28 April 2020

Ms Genevieve Lucas  
Department of Planning, Industry and Environment  
320 Pitt Street  
SYDNEY NSW 2001

**Re: Brandy Hill Expansion Project (SSD 5899) – Draft Conditions**

#### Figure 2: Proposed Extraction Stages 1 & 2

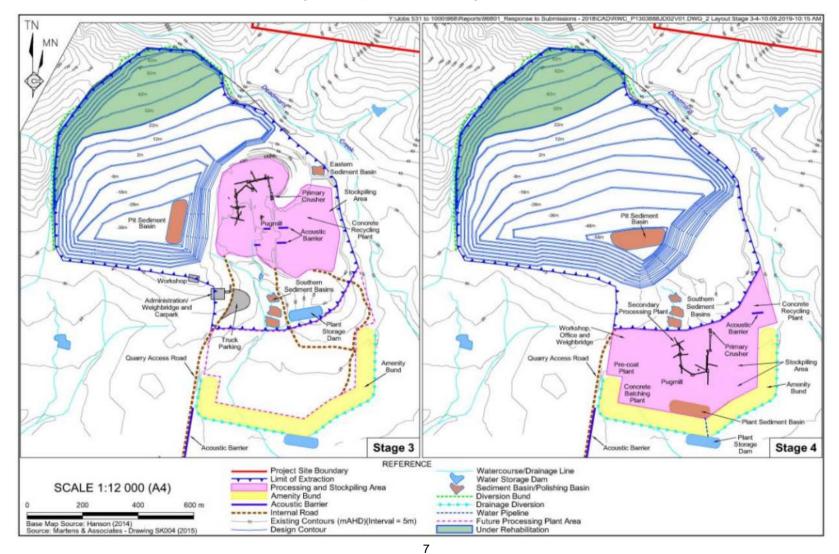
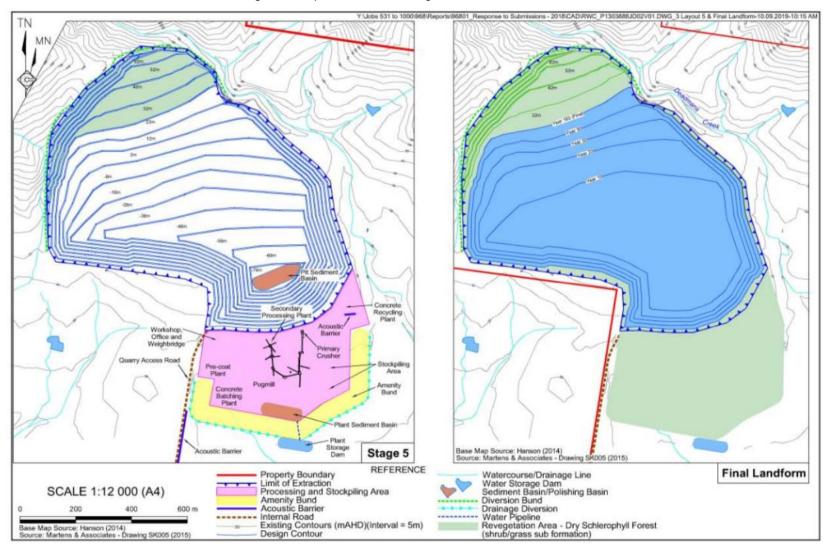
The three figures in this appendix have been amended to remove previous figure titles and the make the final landform consistent with Appendix 6.
